MEMORANDUM

FROM: Jeff Rice, PCD-Engineering
719-520-7877

SUBJECT: SF-22-025 – Eagle Rising **Response to Memo 8/1/2024**
Fourth response to comments

CIVIL CONSULTANTS, INC.
 212 N. WAHSATCH AVE., STE 305
 COLORADO SPRINGS, CO 80903
 PHONE: 719.955.5485
 SHEET 2 OF 5

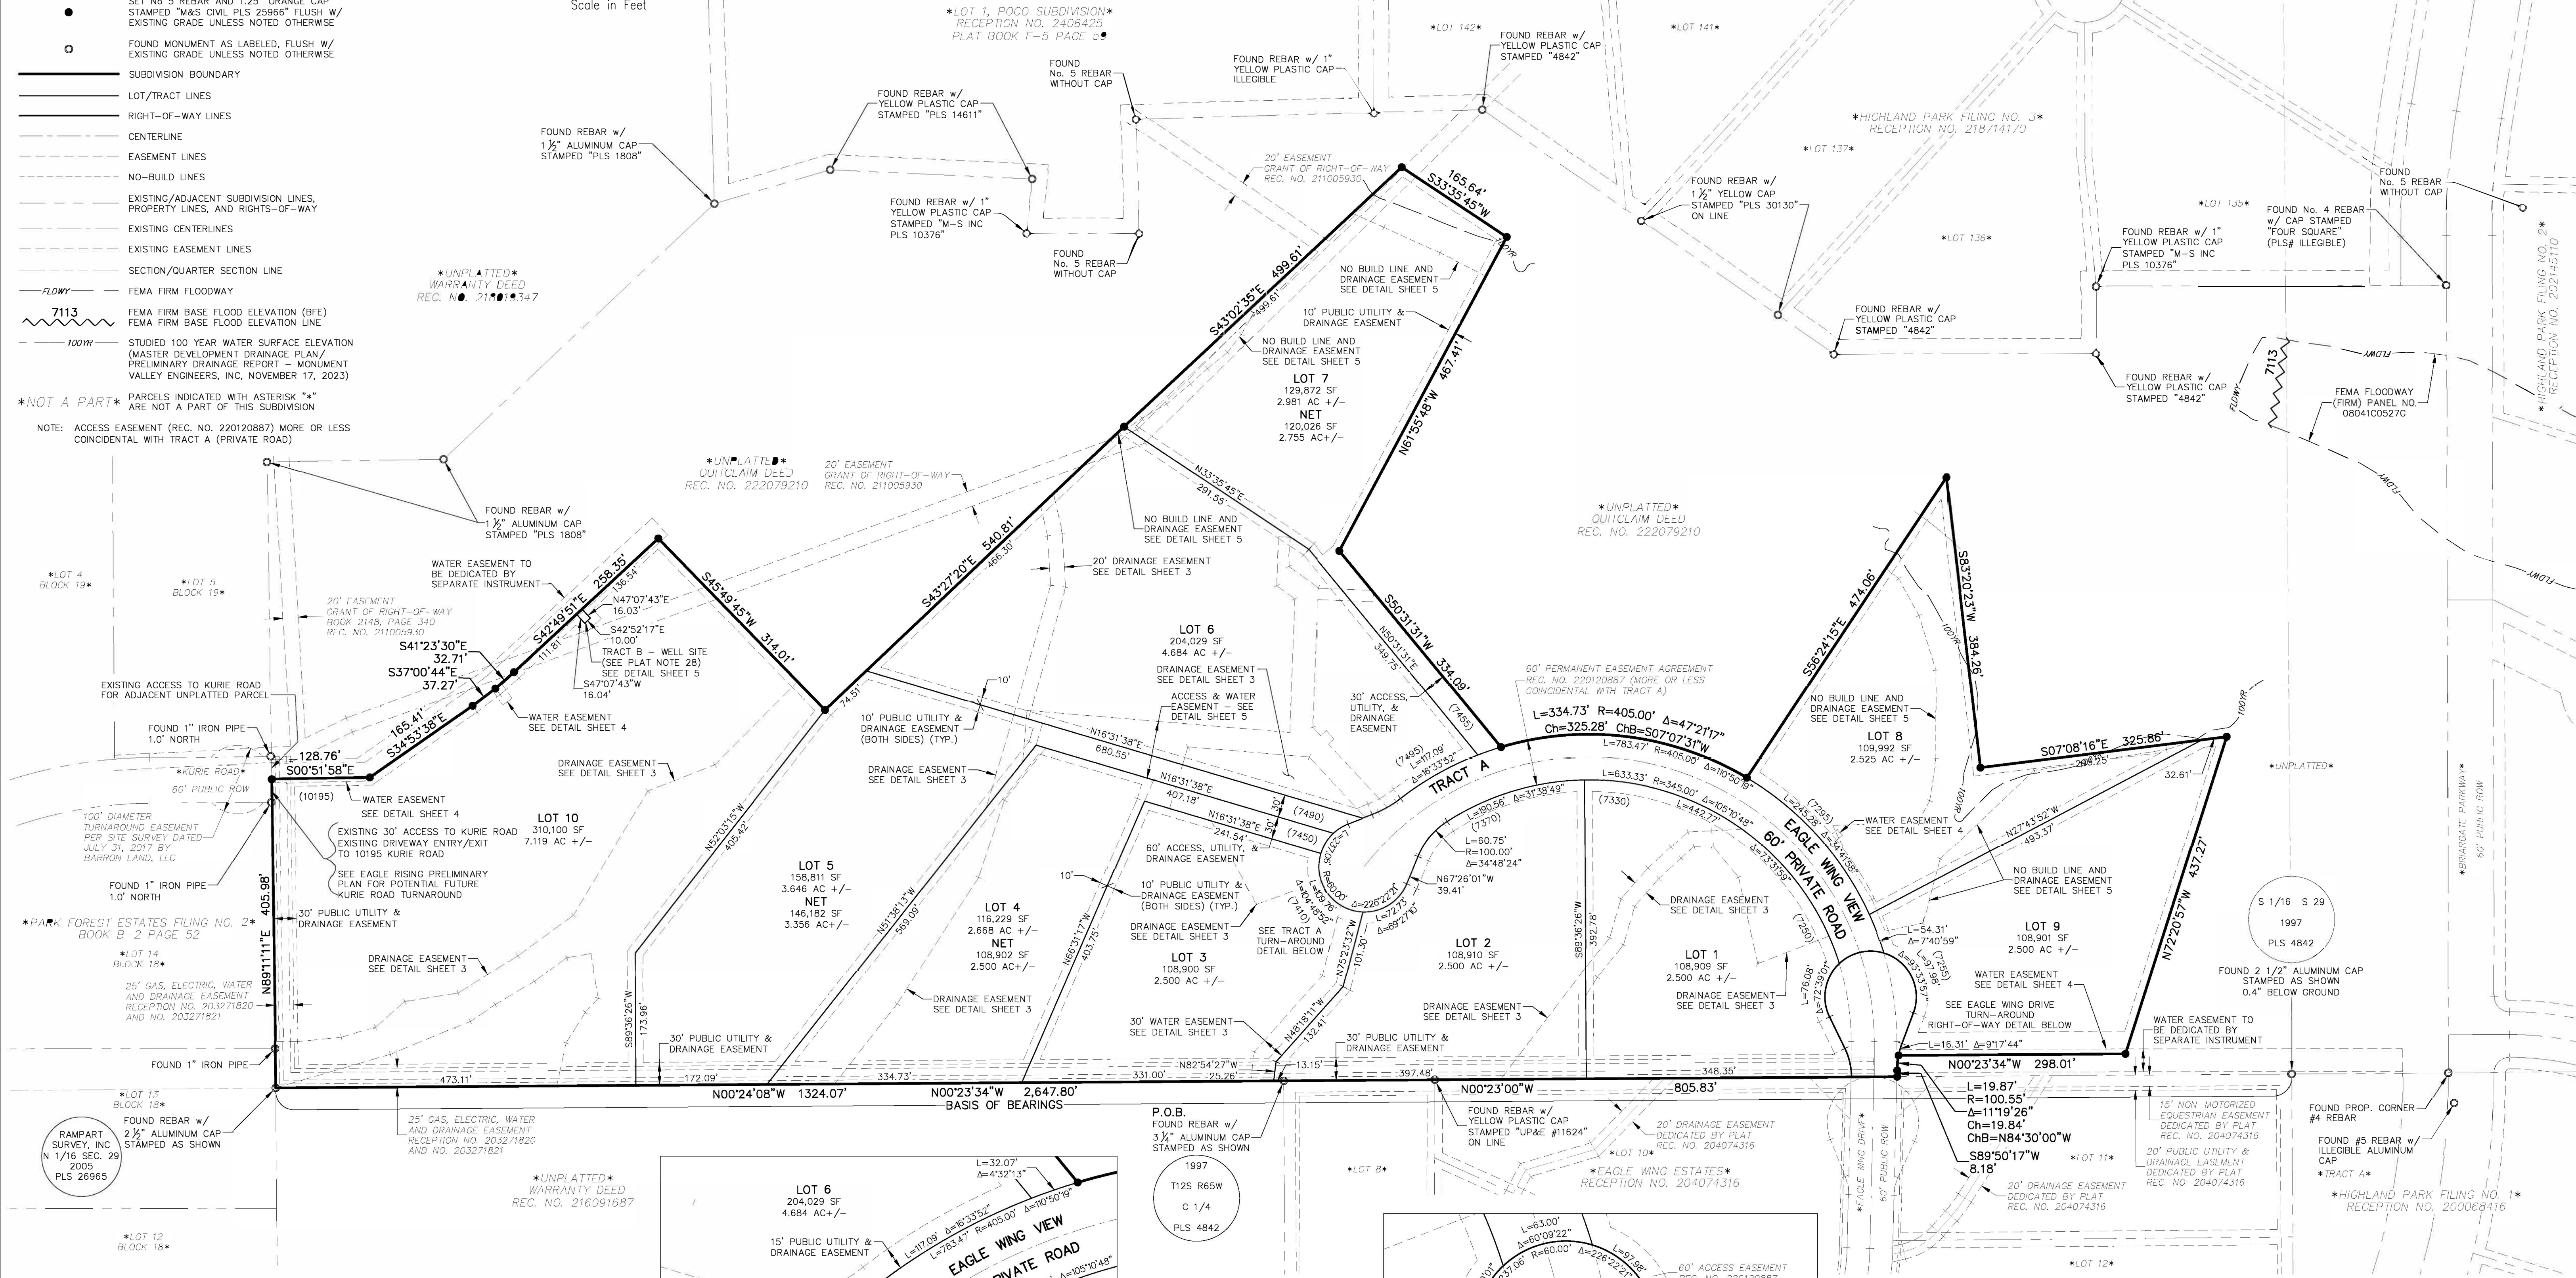
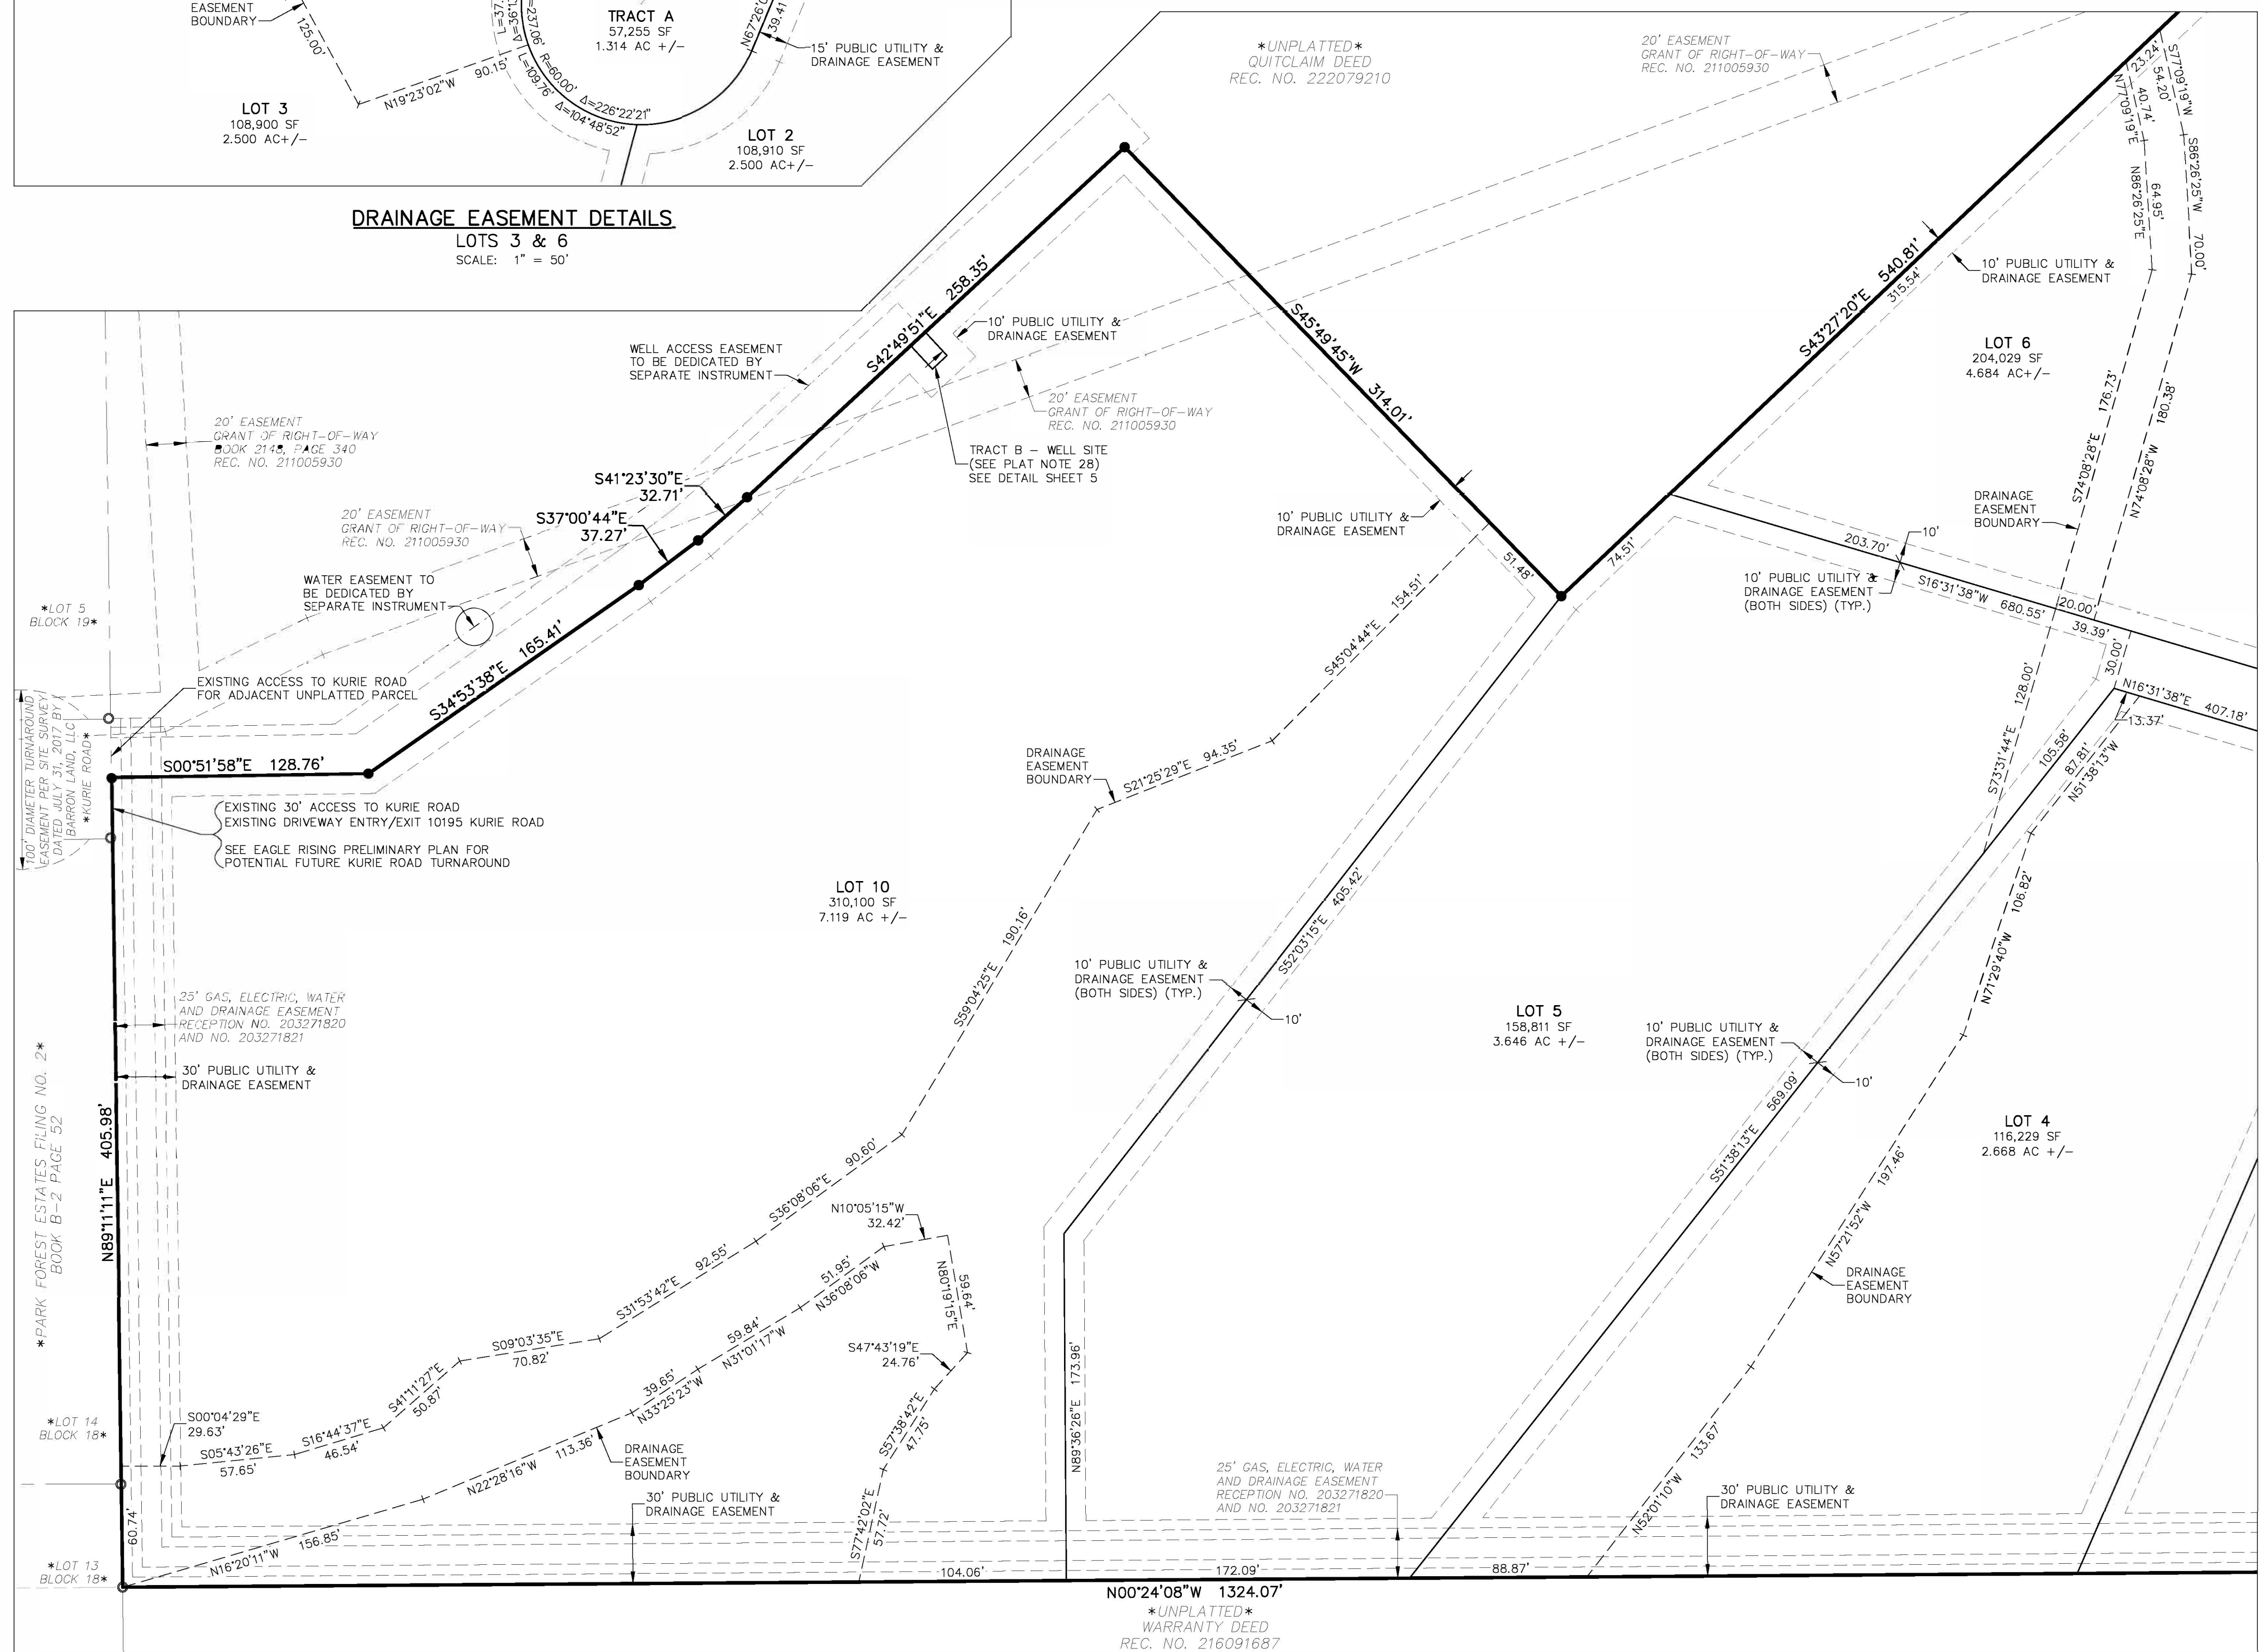
- c. **Resolved.**
4. The plat must dedicate right of way for a cul-de-sac at the south end of Kurie Road. Cul-de-sac dimensions need to match dimensions shown in the standard drawing for cul-de-sac details in the Engineering Criteria Manual so that County vehicles attempting to maintain the roadway and emergency service vehicles may turn around in the public cul-de-sac. Revise Lot 8 as

appropriate. **Unresolved; the portion of the necessary ROW within the final plat area shall be provided in conformance with the preliminary plan. Unresolved.**

6. See cursory final plat redlines. **Partially resolved; see updated/remaining redlines.**
Response: No EPC response to applicants' response on 5.21.2024 as previously stated "The Preliminary Plan shows the complete development of two parcels, 5229000034 and 5229000035. Eagle Rising Filing No. 1 is the final plat for only the western parcel (5229000034). The final plat for Filing No. 1 contains the necessary elements to serve the single-family residential lots as depicted on the Filing No. 1 plat. The approved Preliminary Plan indicates a turnaround will be required for more than two parcels/lots to access Kurrie Rd. An additional Kurrie Road Cul-de-Sac Right of Way is not required on Final Plat Eagle Rising Filing No. 1. Minimum frontage access meets LC 8.4.3.B.e as shown on the plat. See Access Easement Detail Sheet 3 showing the existing approved driveway 30' access easement to Kurrie Road that is platted as a permanent existing turnaround. No additional ROW needed."
